Job 72342822REP1	Truss 2FG1	Truss Type Truss	Qty 1	Ply 1	Professional / Raleigh Farmhouse - F2 Job Reference (optional)
---------------------	---------------	---------------------	----------	----------	---

Repair for nine damaged plates as shown.

**RALEIGH FARMHOUSE  
2ND FLOOR**

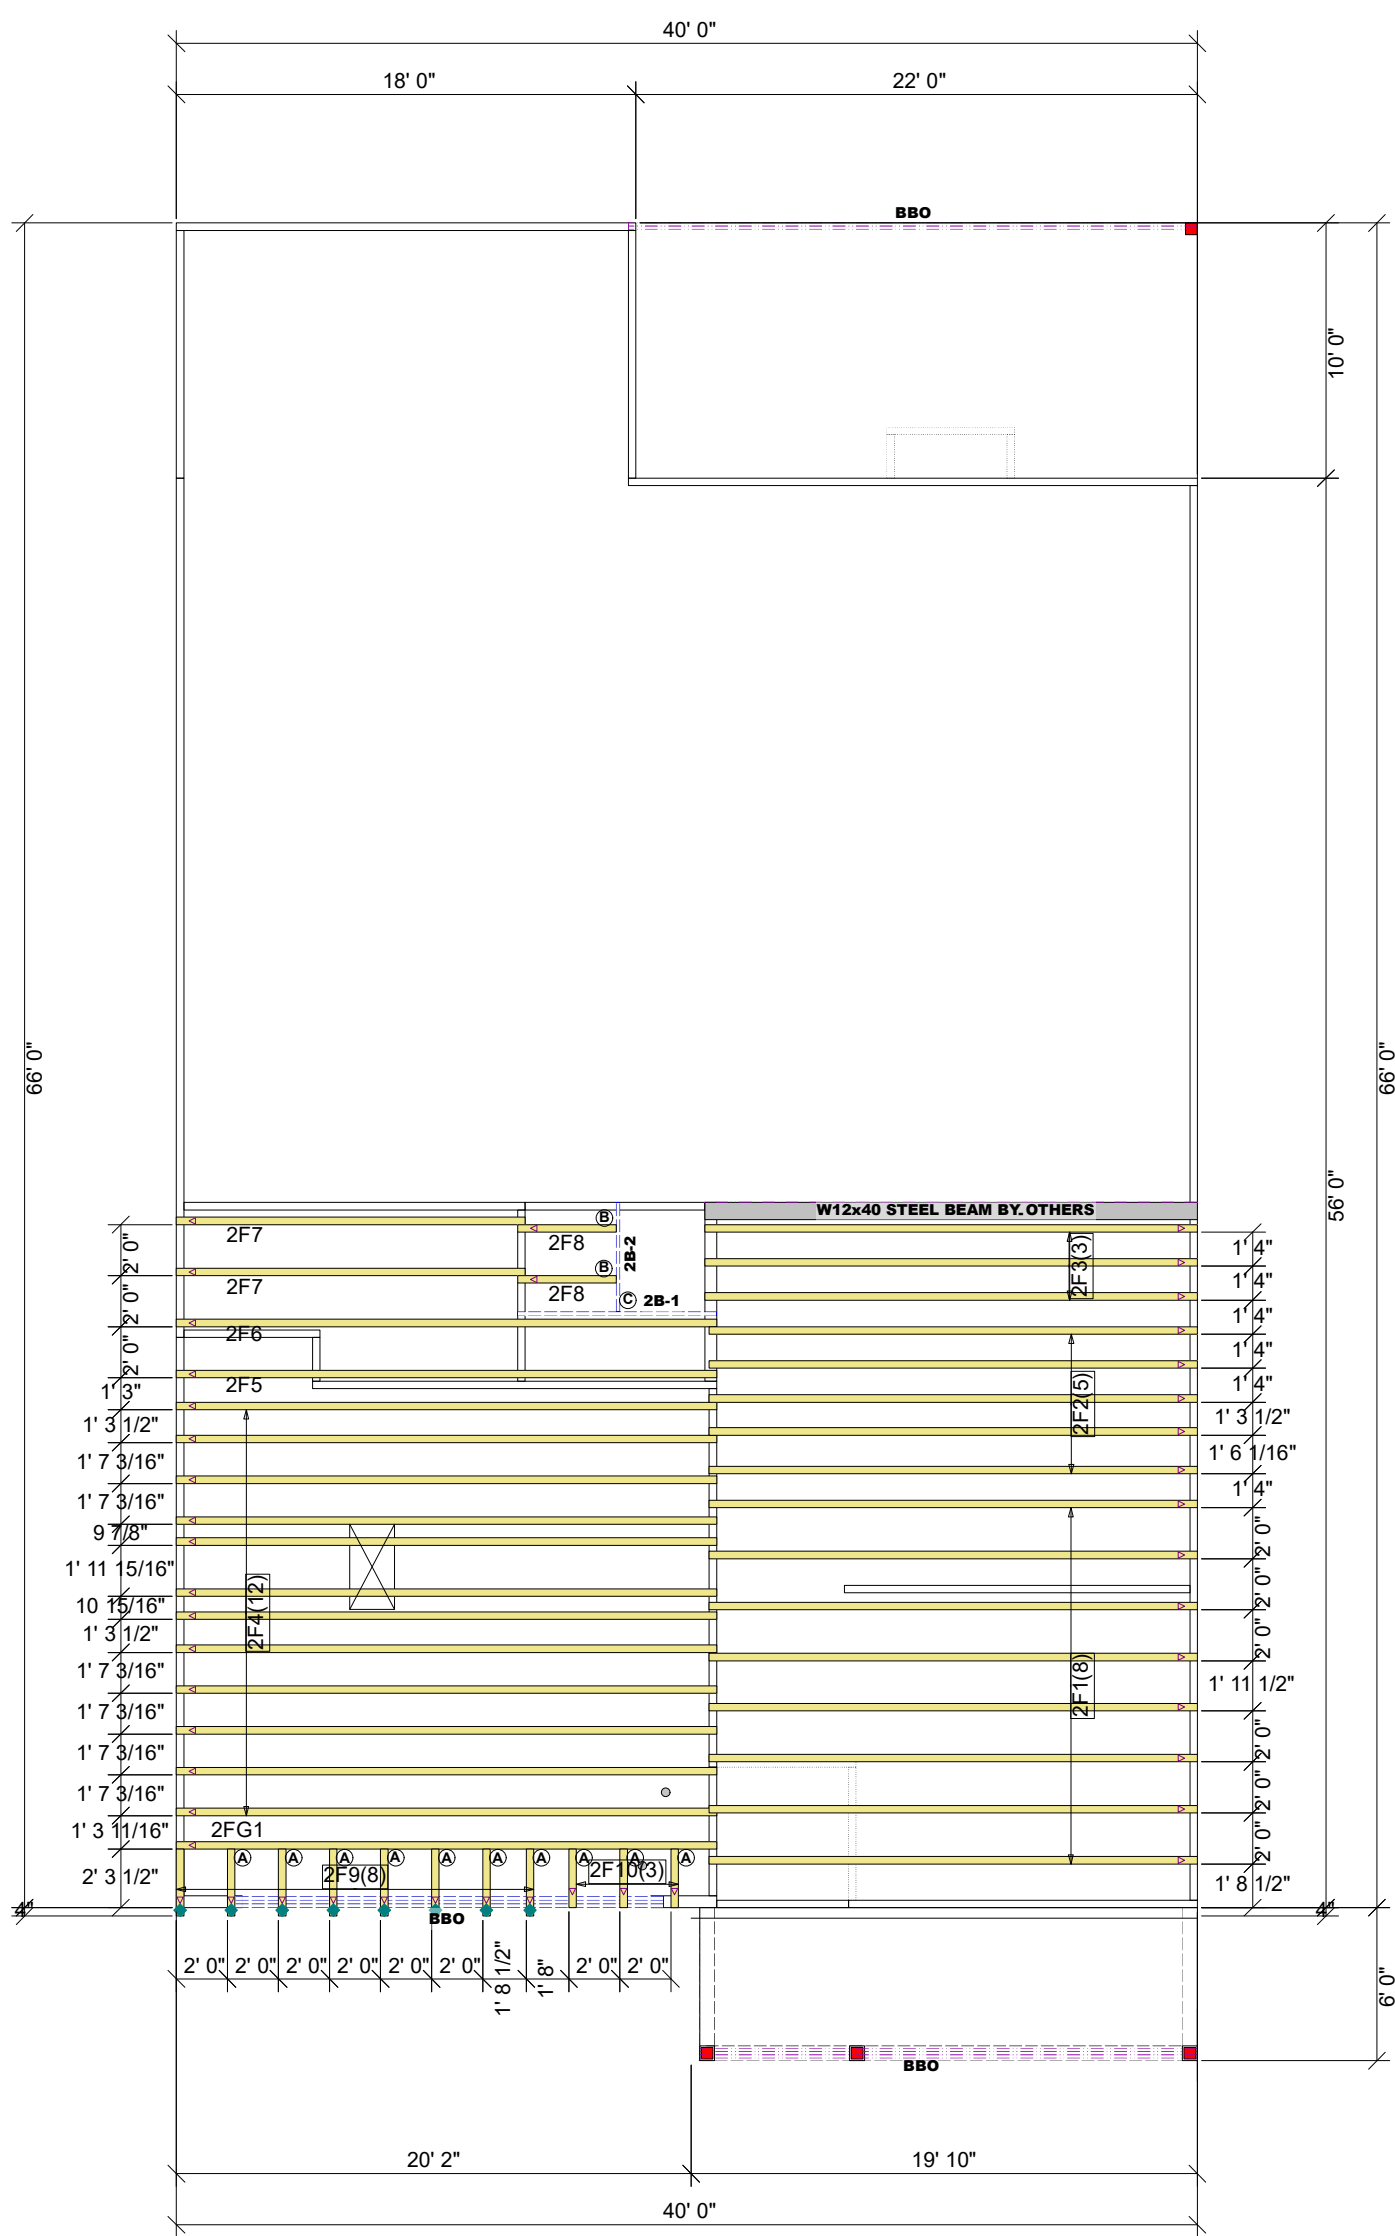
Attach 1.75" x 14" x 20-11-0 2.0E Microllam LVL (or equivalent) scab to one face of truss as shown with 16d (.162" x 3.5") nails 6" oc in all top/bottom chord members, 294 and two evenly spaced 16d nails in each web.
